**Jacfin Pty Ltd - Submission on ESR Horsley Logistics Park
State Significant Development Application 10436
Site: 6 Johnston Crescent, Horsley Park**

We refer to State Significant Development Application 10436 (**Application**), by which ESR Developments (Australia) Pty Ltd (**Proponent**) seeks approval for the development of a new industrial warehouse and distribution precinct, including the construction and fit-out of six warehouses, on-lot stormwater, infrastructure and services (**Development**) on the Site.

RE: Objection to State Significant Development Application ESR Horsley Logistics Park

LEGEND

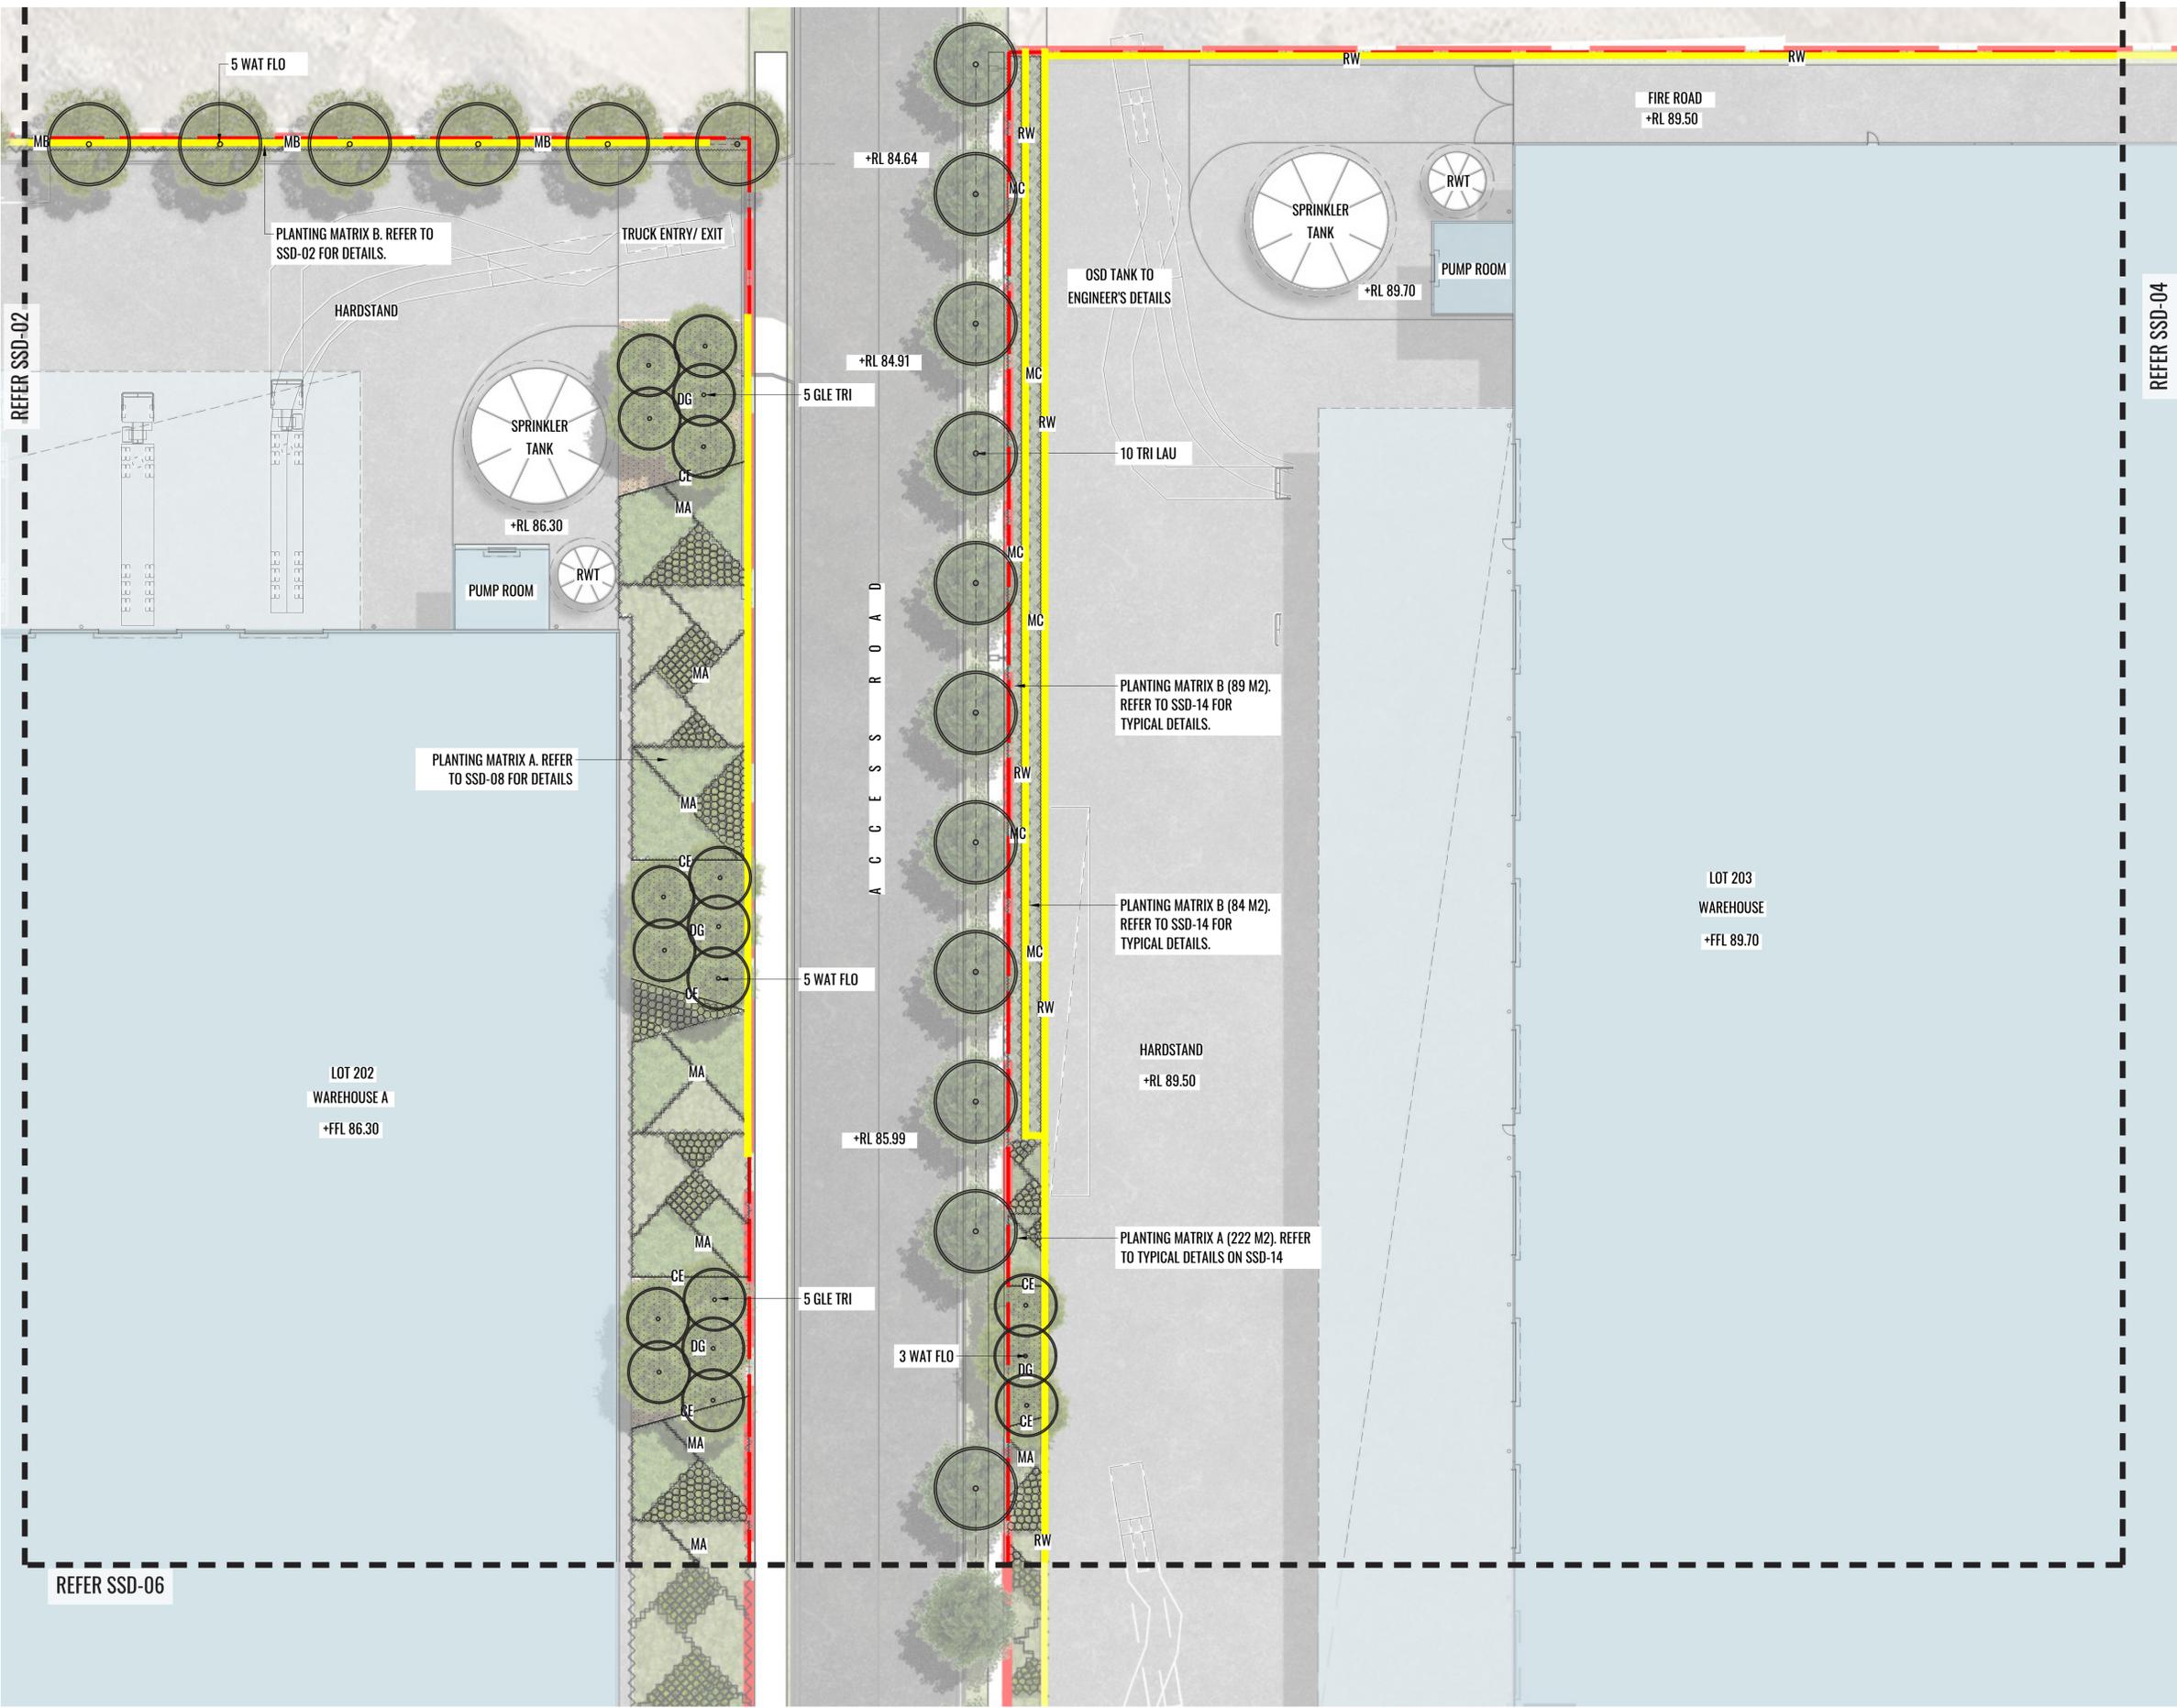
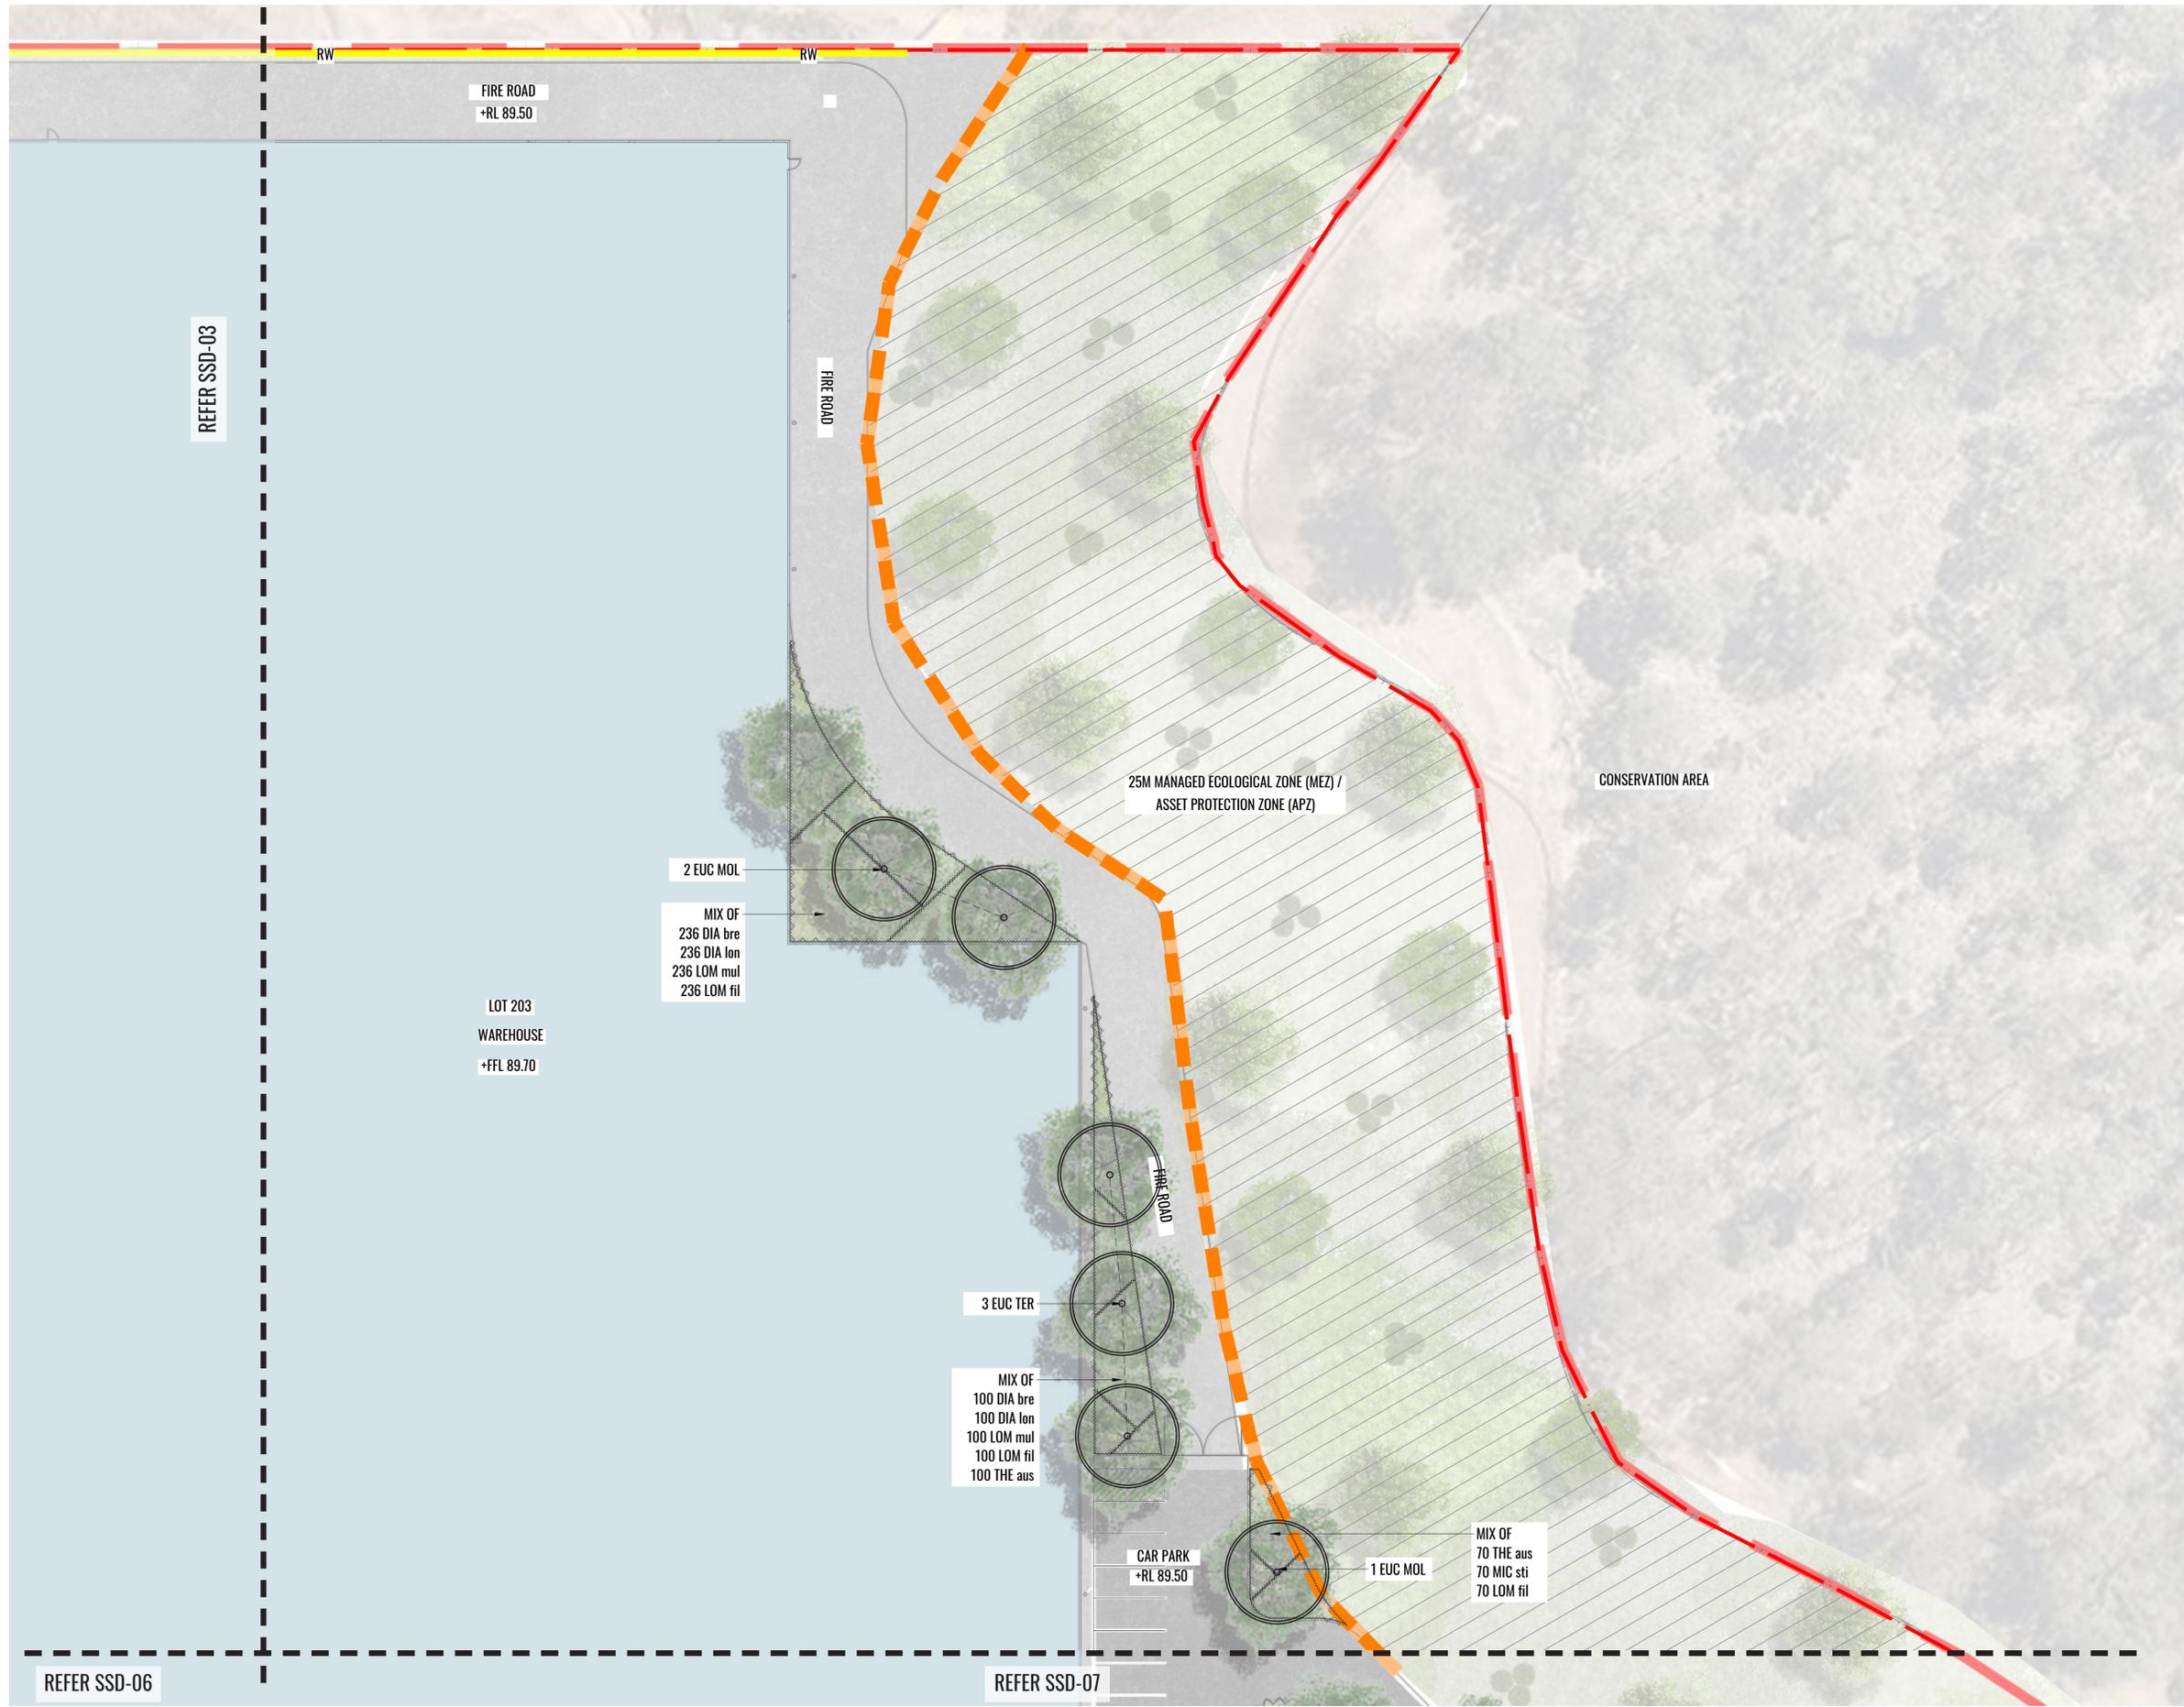
The Landscape Plans prepared by Geo Scapes (Drawing No. LDA-01 Revision C) show the proposed setback, however outline that "Southern landscape buffer (by others)". The landscape plan suggests that the landscaping of this buffer is provided under DA893.6/2013 and therefore does not need to be shown on this application. The maintenance of the landscaped setback will be the responsibility of ESR and should therefore be detailed on the EIS and be suitably conditioned. The EIS should also consider the existing and proposed height of the landscaping at the time of construction noting Commissioner Morris's comments in the judgement [70]:

The proposal needs to be amended to show a greater planted setback in line with the conditions of the Court. Furthermore the landscaping for the buffer needs to be considered as part of this EIS in the context of the buildings proposed to ensure the landscaping is dense and large enough to properly screen the proposed development.
